## KITTITAS COUNTY COMMUNITY DEVELOPMENT SERVICES

January 13<sup>th</sup>, 2017

After review of relevant sections of the Shoreline Master Program, the following determinations have been made in regards to your proposed structure. Considering that the primary structure for the existing home is approximately 54 feet from the Ordinary High Water Mark, the Kittitas County Shoreline Master Program (SMP) 7.2(4) applies, with the existing residence qualifying as a nonconforming structure.

SITE PLAN

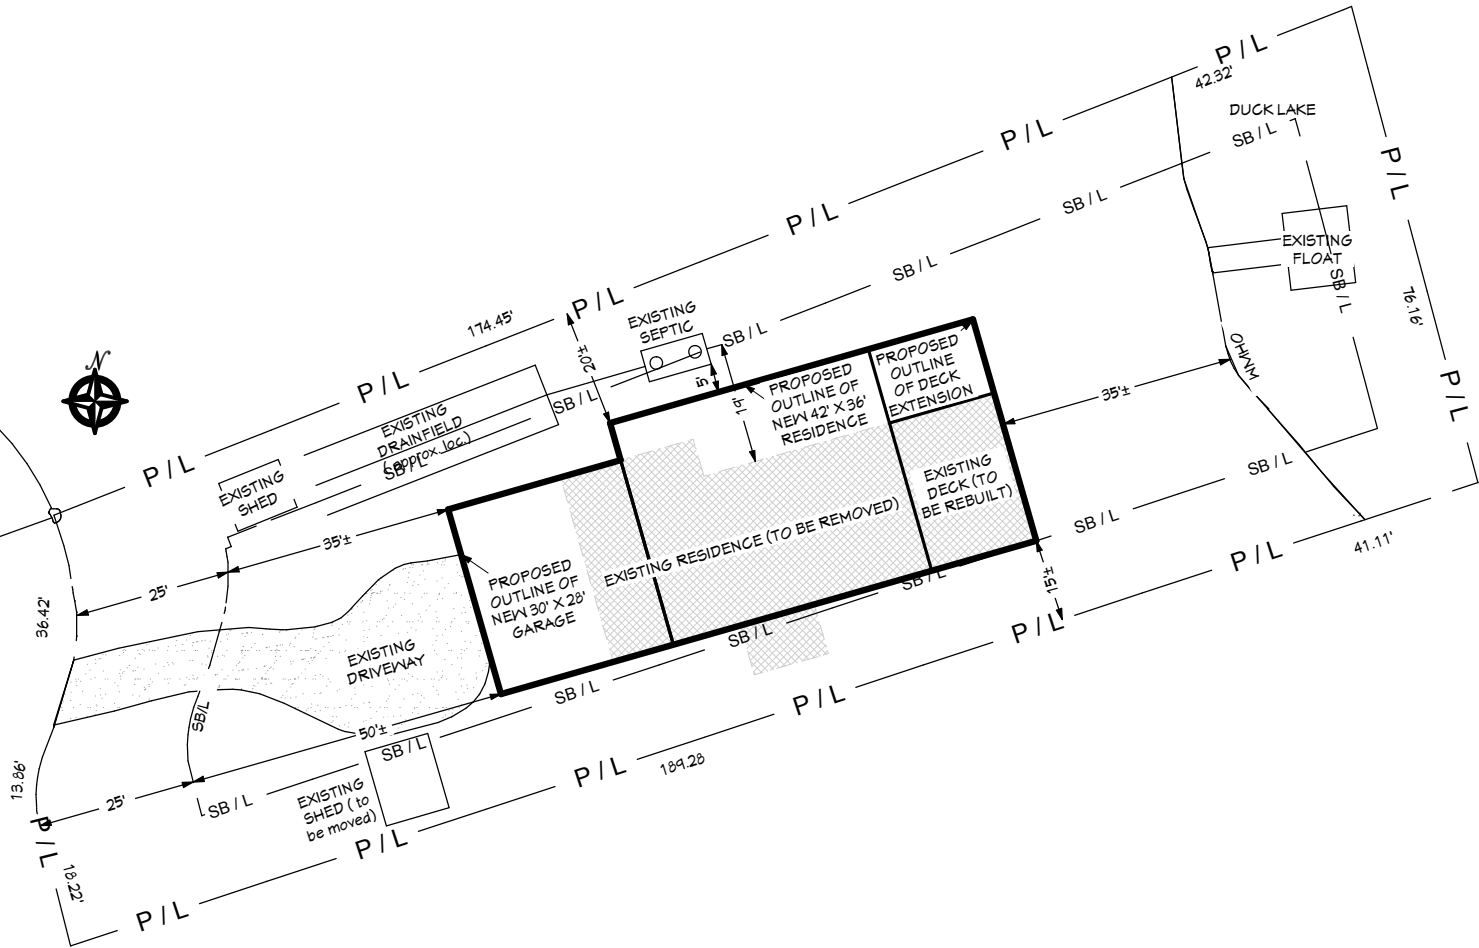
The structure is legally established, though nonconforming due to the short distance from the OHWM. As a single family residence, the structure is allowed under the use provisions of the SMP. Under SMP 7.2(4)(c)(iv) above, expanding the existing structure is allowed without a variance provided that it can be demonstrated that the expansion will result in “no net loss” of ecological function, and that the expansion does not move the existing structure closer to the shoreline.

The original proposal included removing and the rebuilding the structure. Under SMP 7.2(4)(c)(vi), removing and then replacing the structure will require a variance in order to bring it into compliance with the SMP.

The proposed residence may run into an issue with 7.(6)(b)(i). The provision can be interpreted to mean that the existing use is “reasonable”. To summarize, expansion of the existing structure is permitted without obtaining a variance provided that the expansion moves no closer to the OHWM, and removing and replacing the structure will require a variance.
